Deadline 10 – Summary of Position

File Ref: PZ/CS/P21-2329/03TN

Subject: **Fordley Hall – Deadline 10 Submission**

PLAN 1G(a)
SIZEWELL LINK ROAD
SITE PLAN

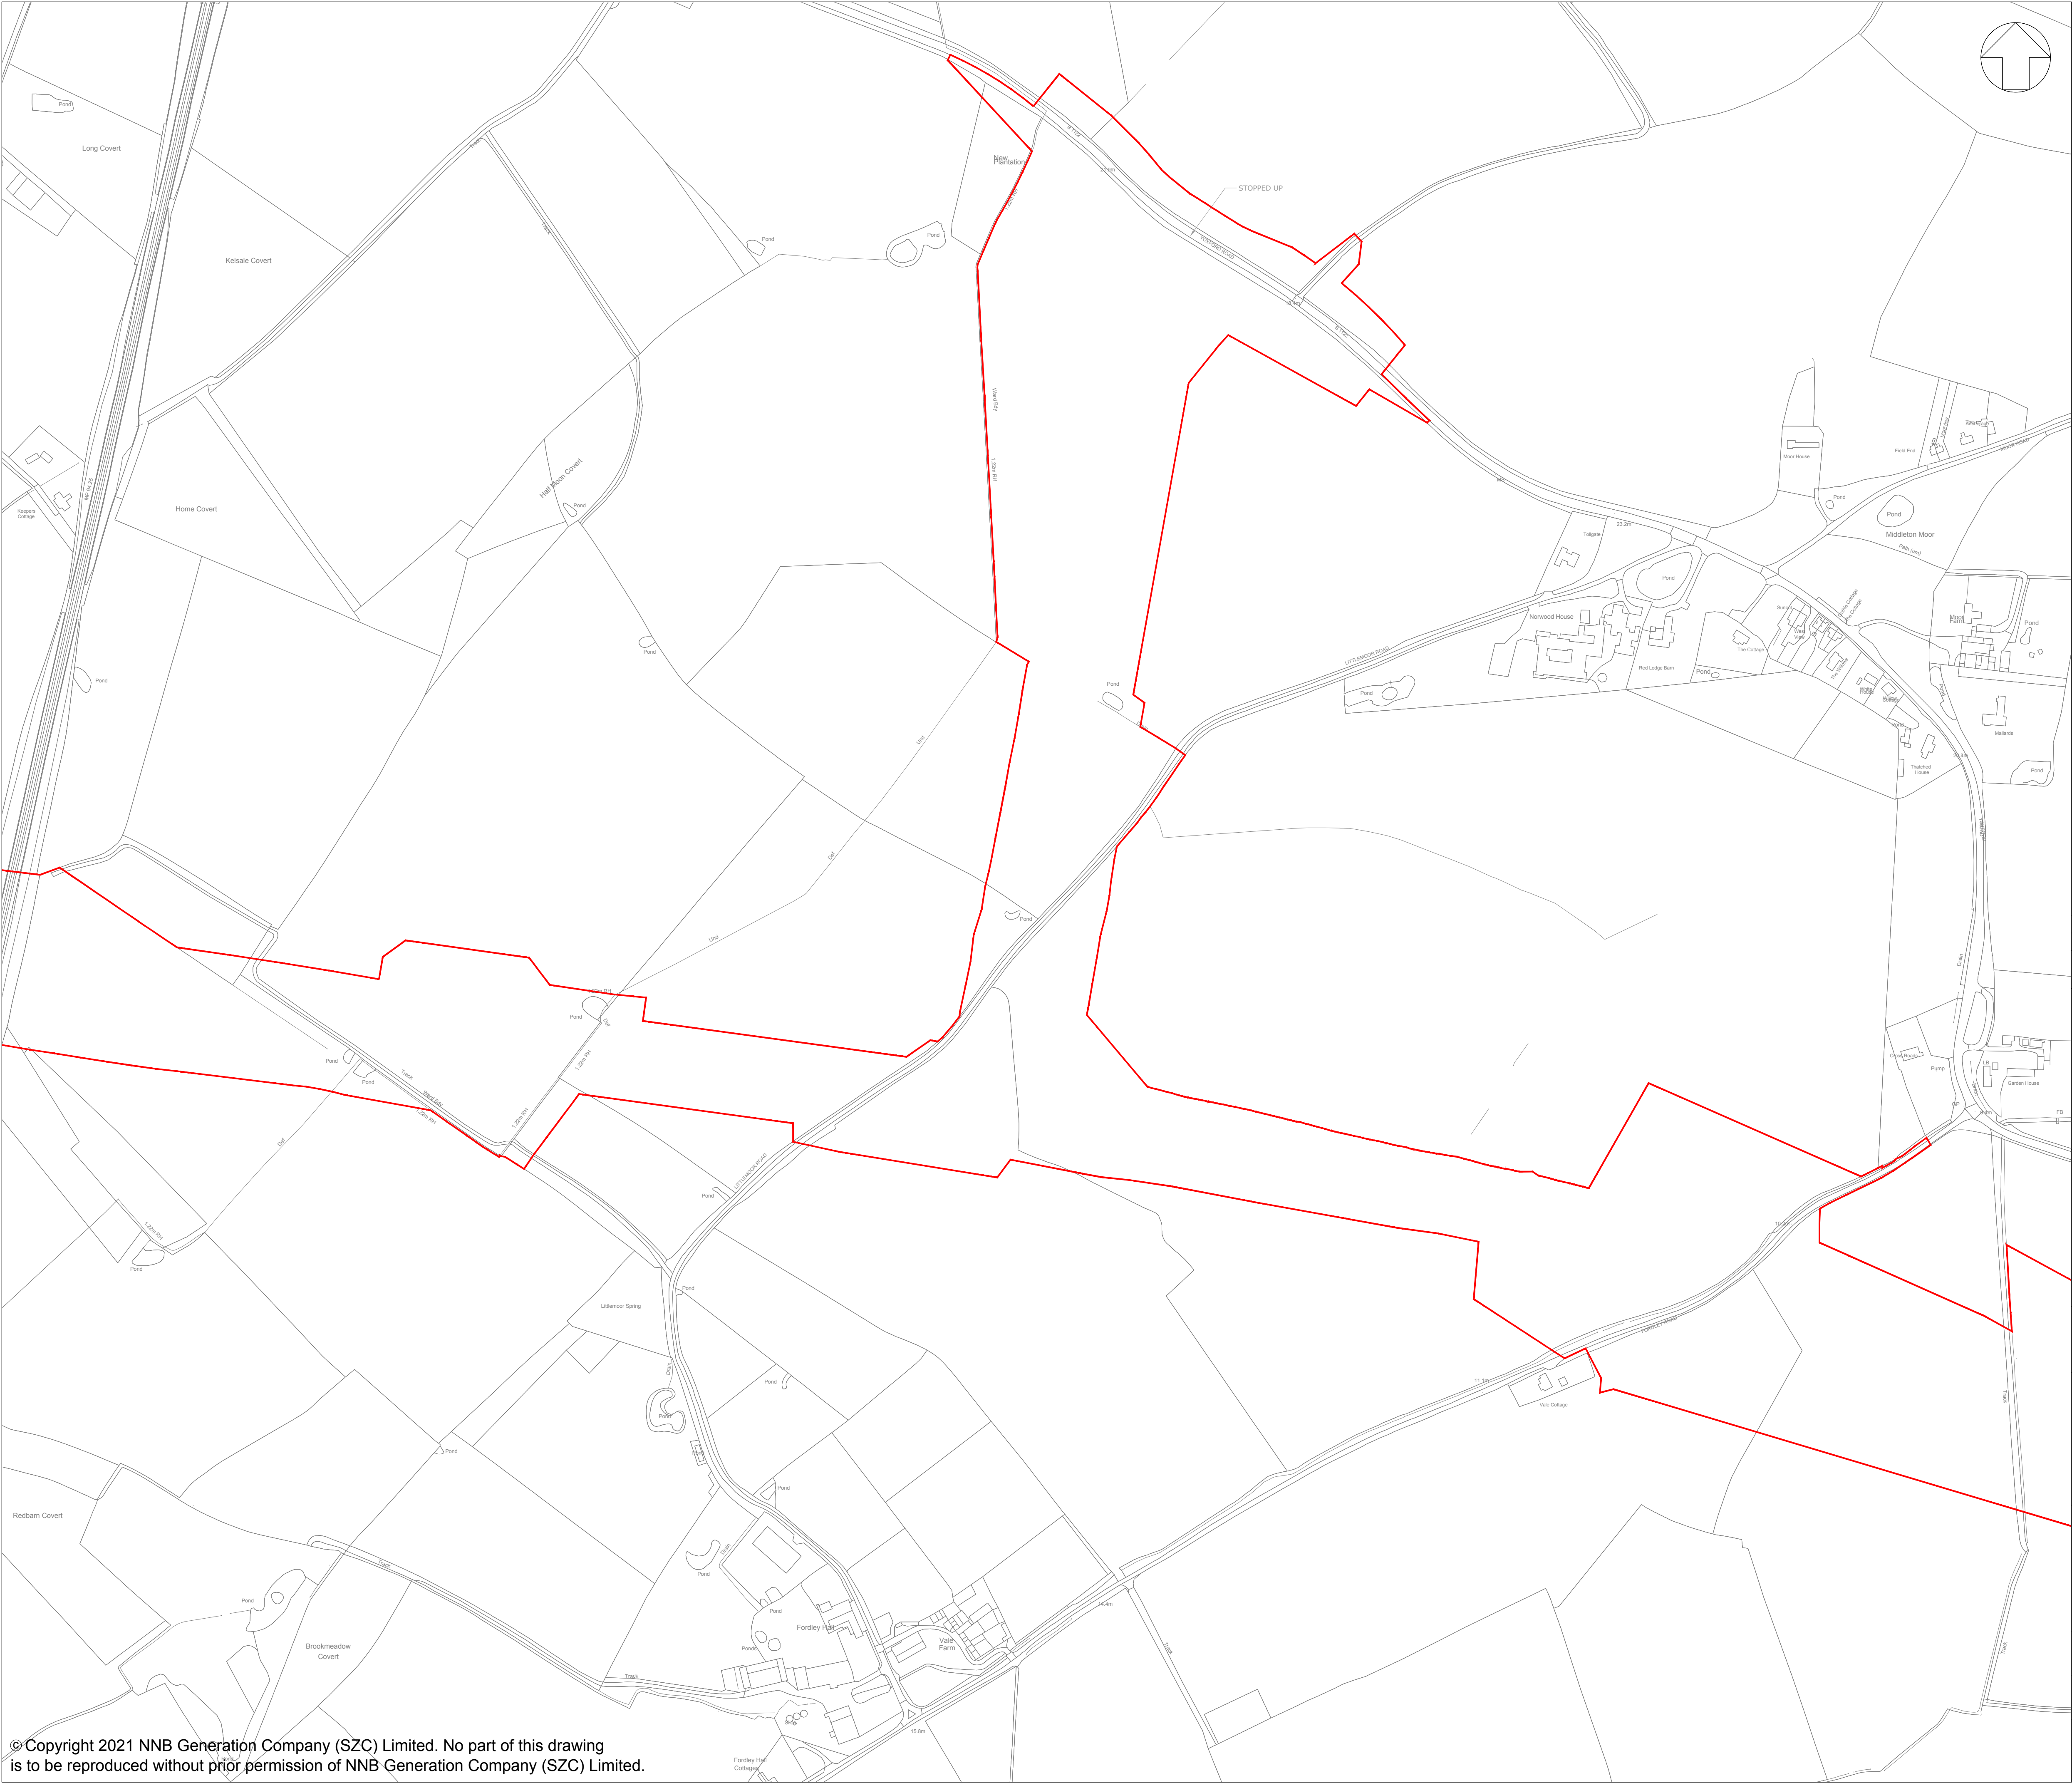
- 2.8 Through discussions with the Applicant, Create have highlighted that the planned noise mitigation measures are not sufficient, both in terms of design or length, to provide a reasonable level of mitigation at Fordley Hall.
- 2.9 Create have highlighted to the Applicant that the current proposals fail to take into consideration the SLR alignment and current topography of the surrounding area and an alternative proposal has been suggested to the Applicant. This is indicated in the extract below as a solid red line and should be a 3m barrier.

- 2.10 The option suggested offers a level of noise attenuation which is considered reasonable against the ambient background noise levels.
- 2.11 Create suggest there is sufficient space within the DCO boundary for a bund to be provided rather than an acoustic fence, which can be landscaped to provide further protection from the potential light spill from the SLR.
- 2.12 This is not contained within the Statement of Common Ground and at this time Create await agreement from the Applicant to this change.
